TRAFFIC IMPACT STUDY

**Jones Road Property
El Paso County, Colorado**

September 2023

PCD File No. P251

Figure 1
SITE LOCATION

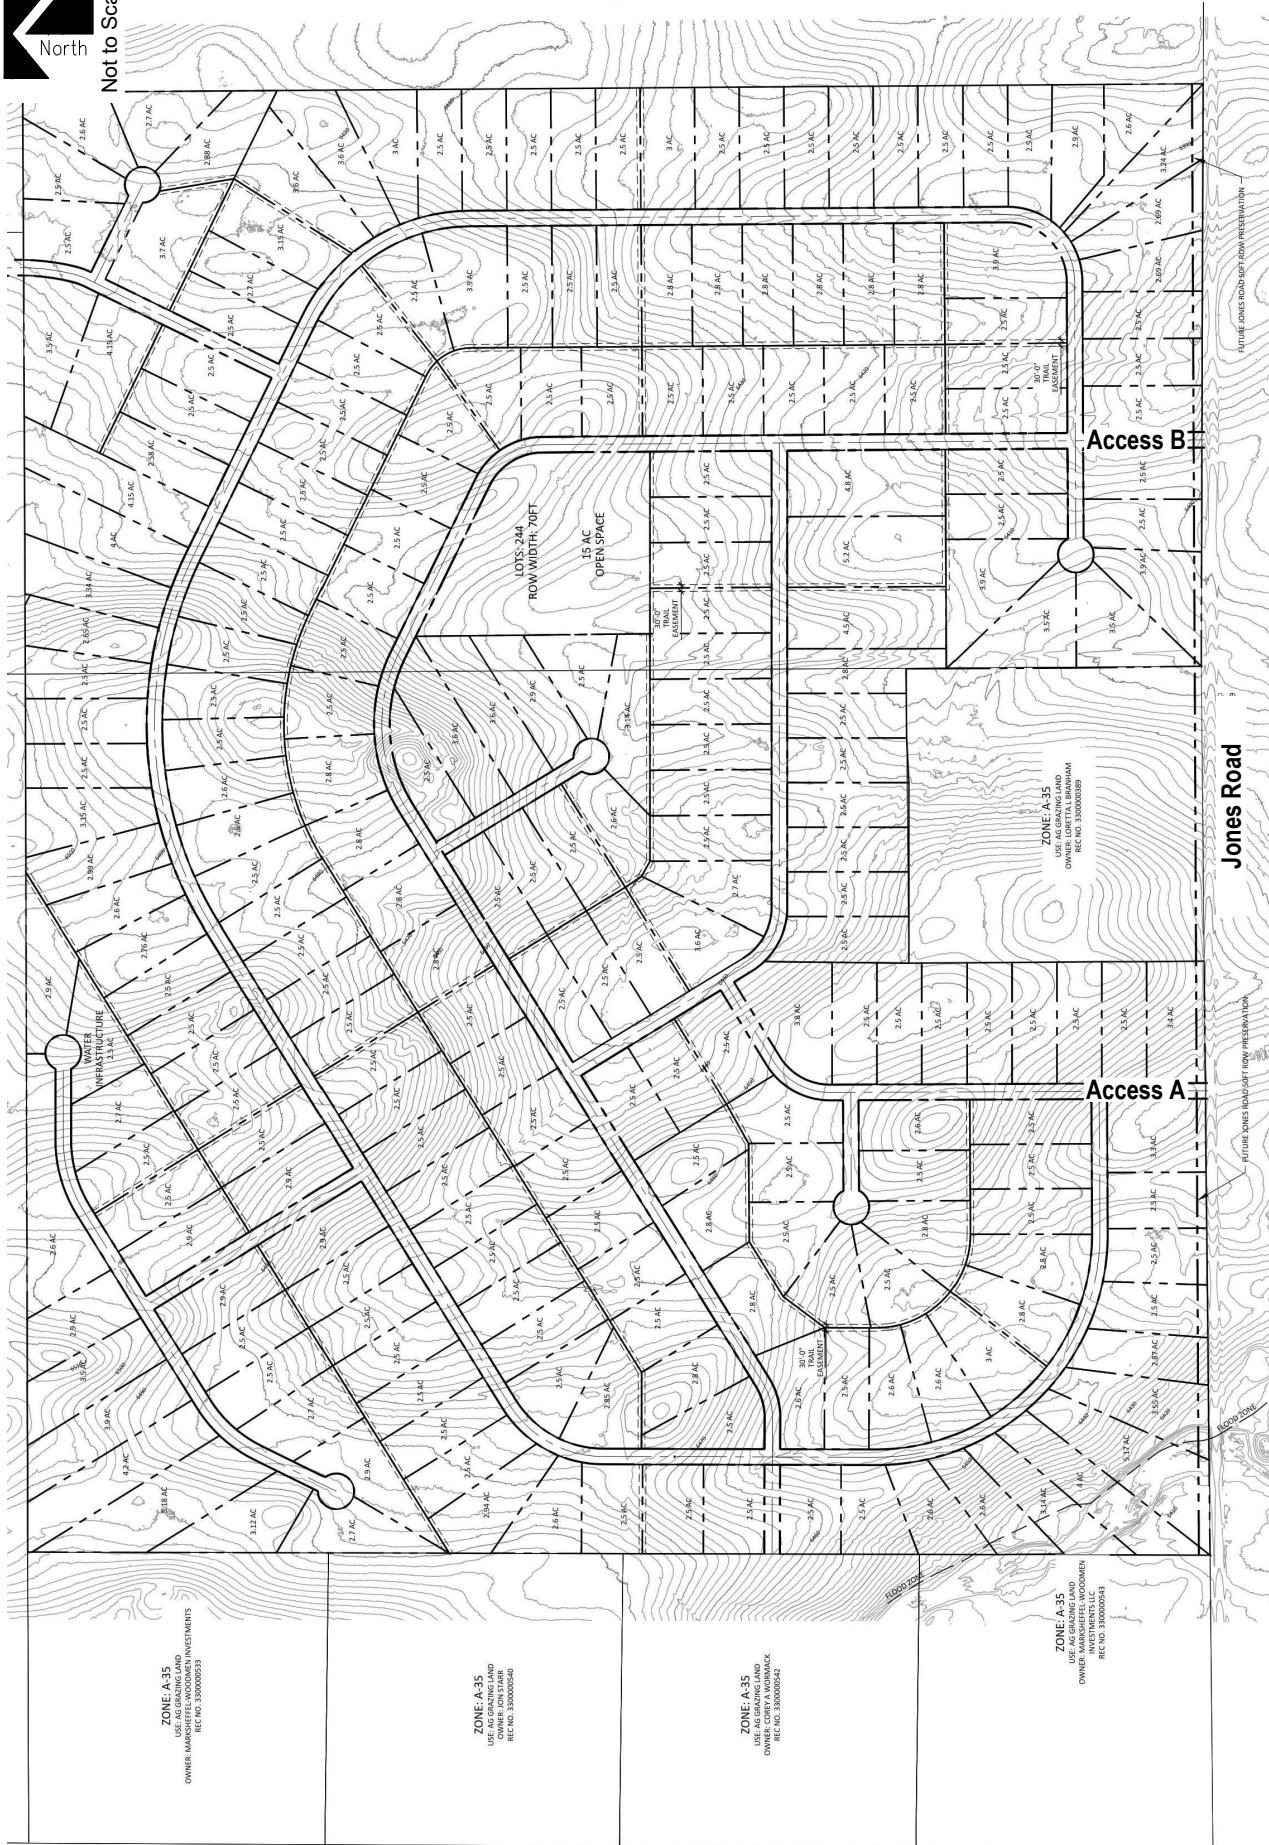
No longer accurate. Please revise to current projections.

Please address right of way preservation shown on the concept figure.

Figure 7
TOTAL TRAFFIC - YEAR 2025
 Volumes
 AM / PM Peak Hour
 (ADT) : Average Daily Traffic

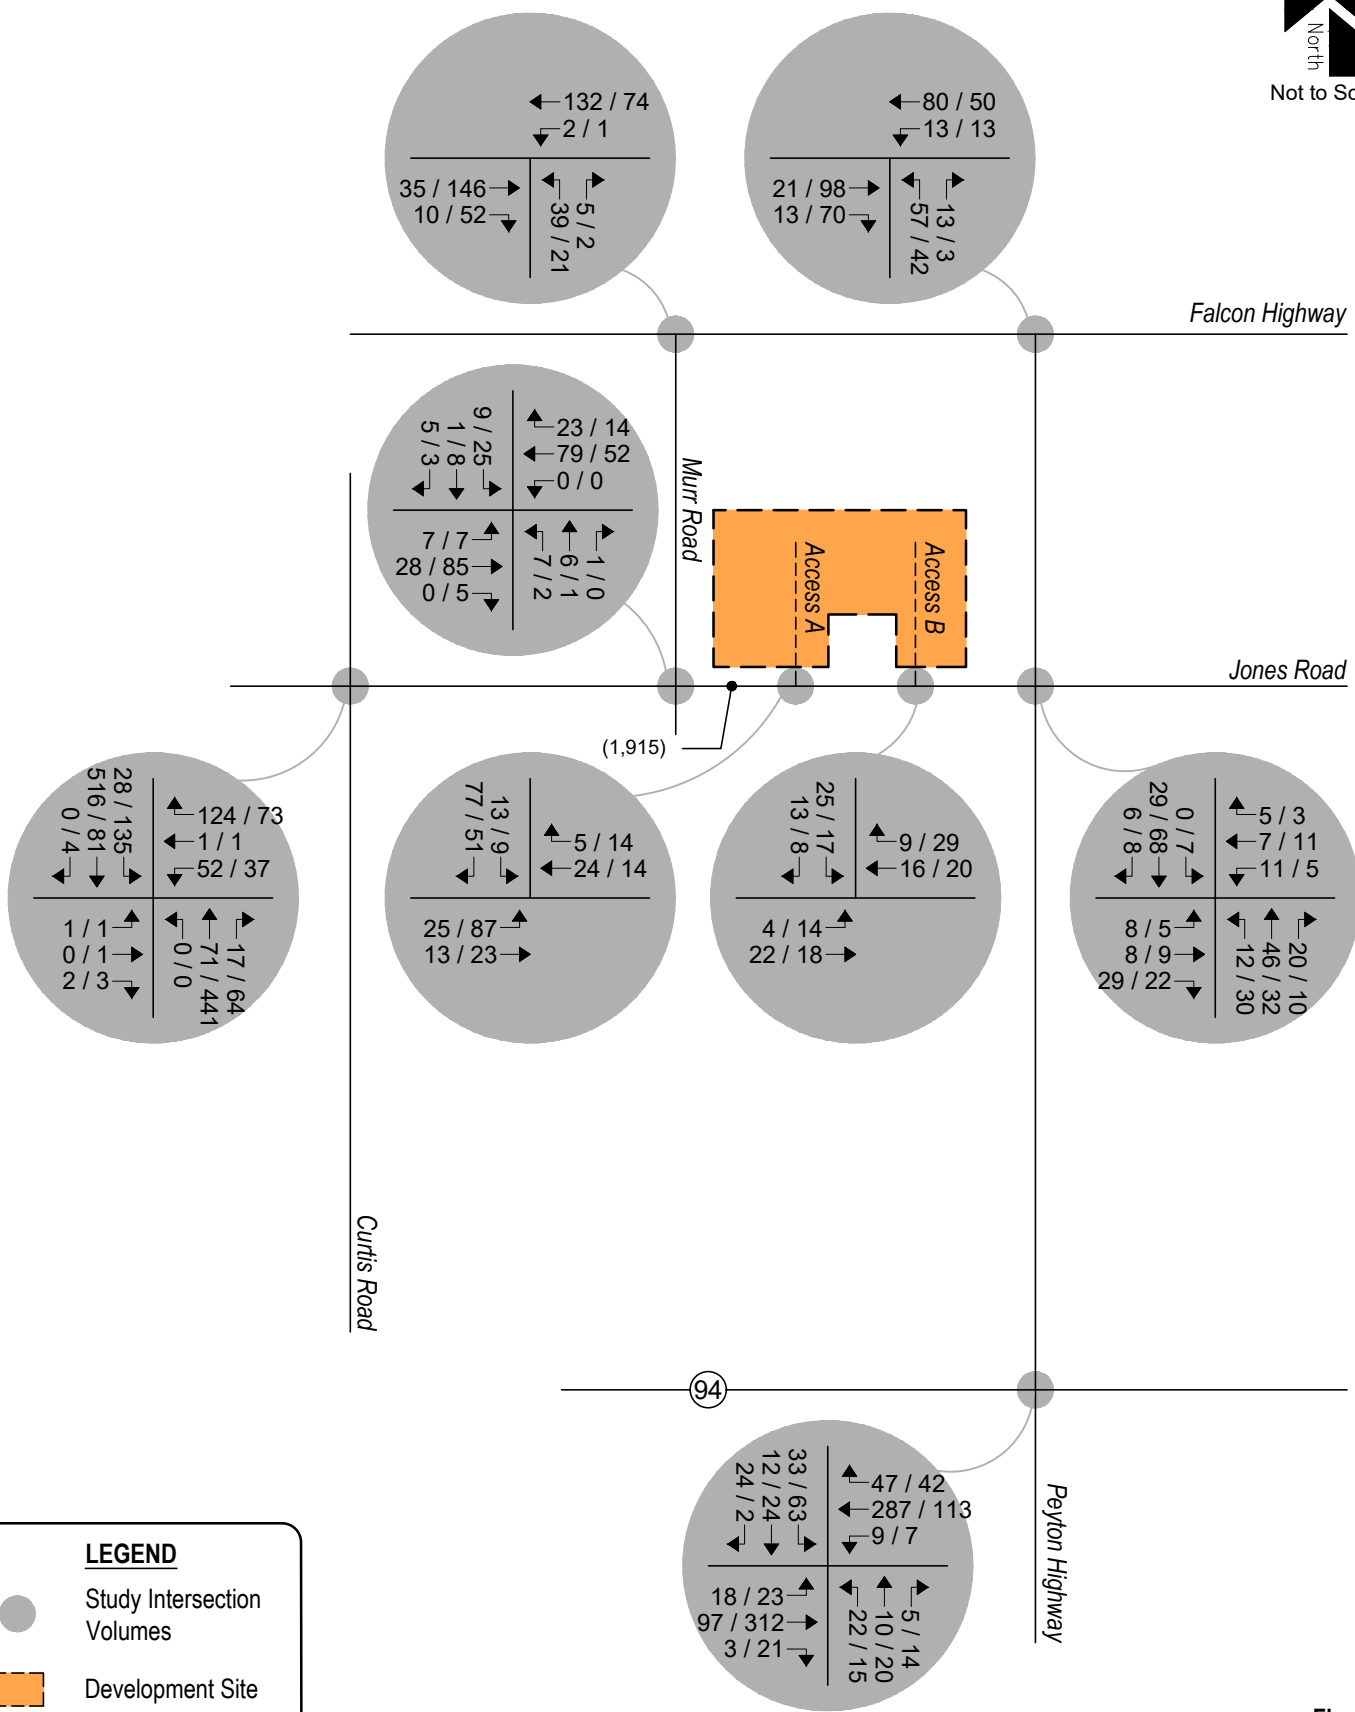
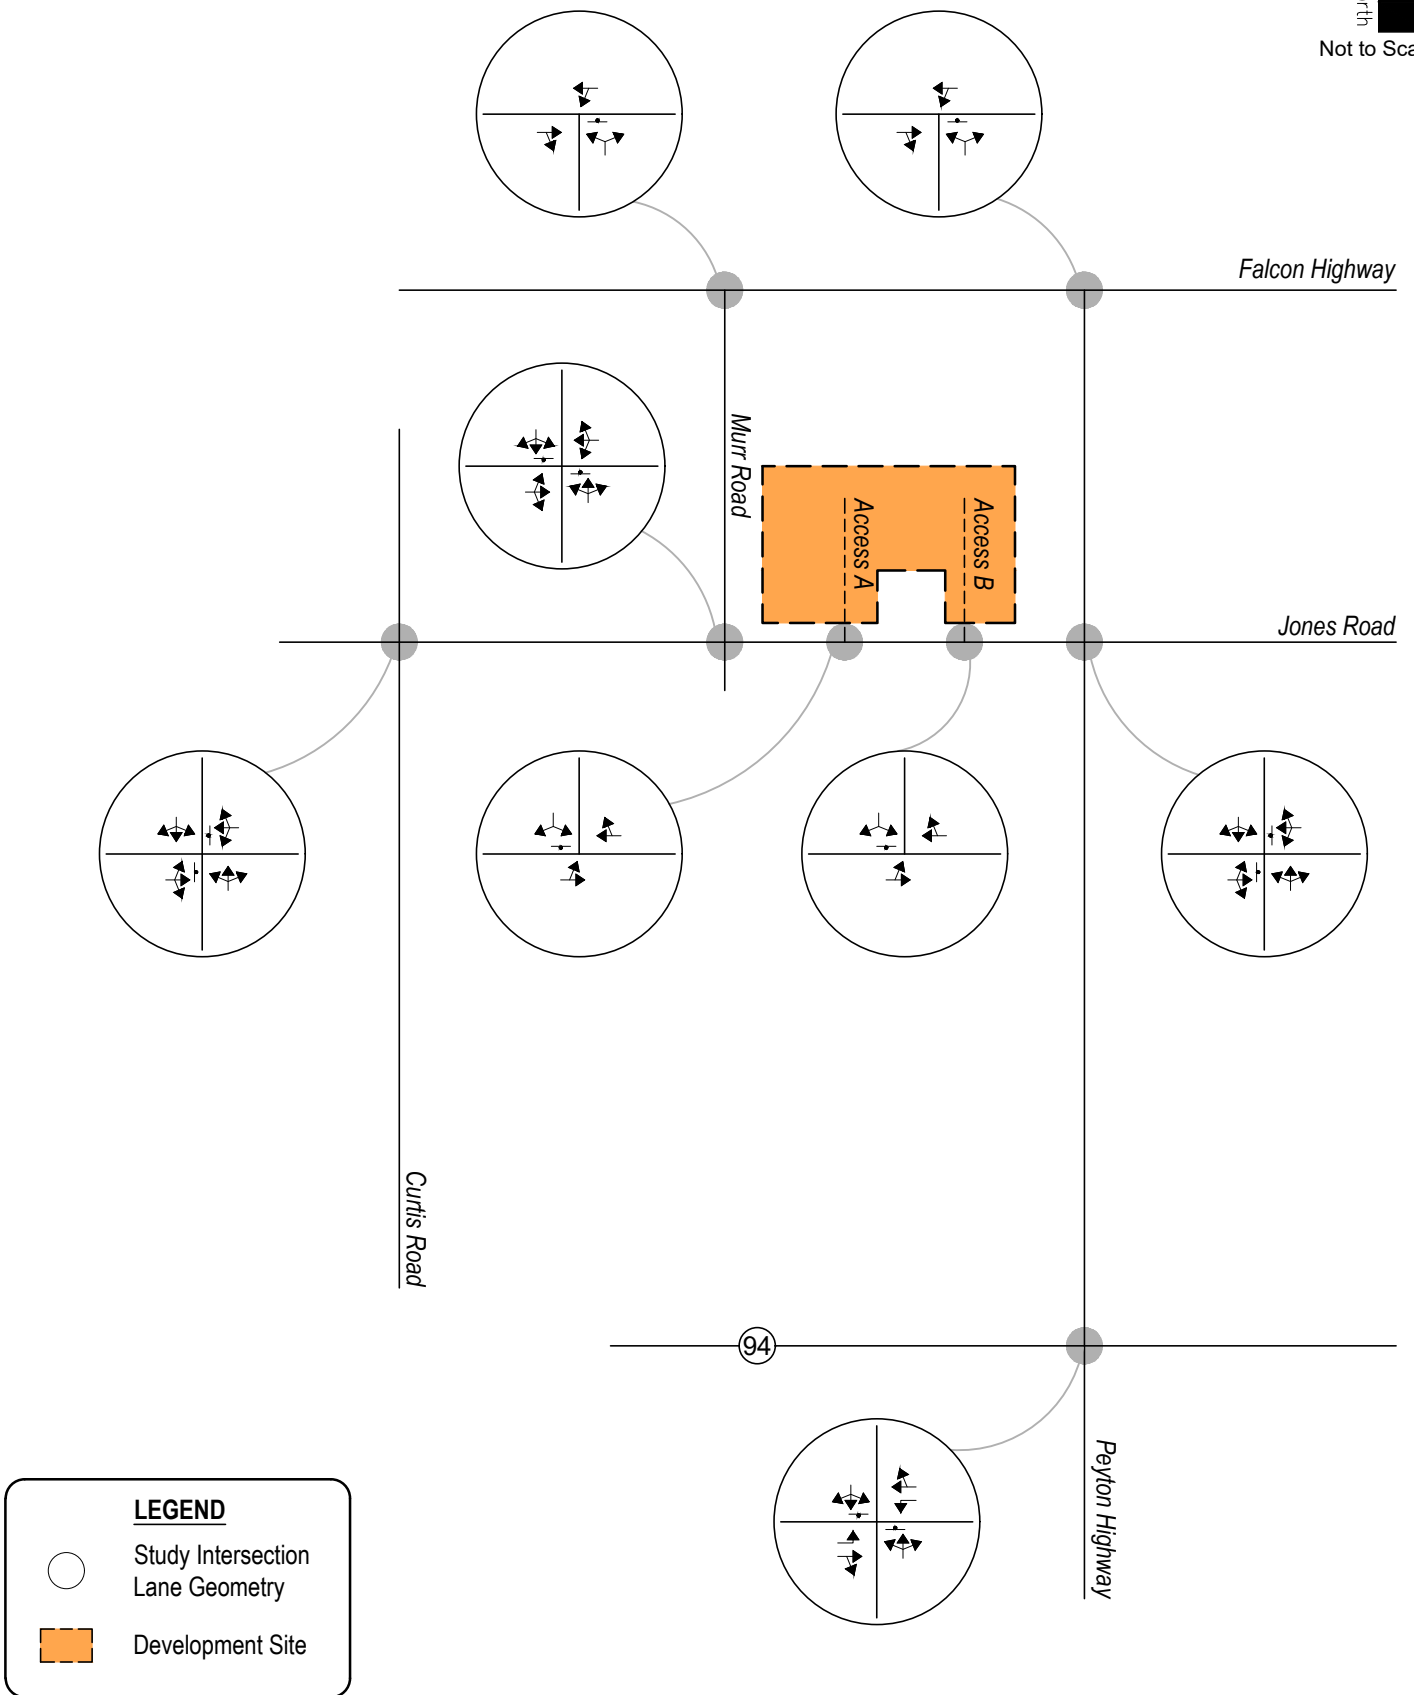
Please discuss whether the the turning movements exceed the ECM threshold for auxiliary turn lanes based on traffic volume.
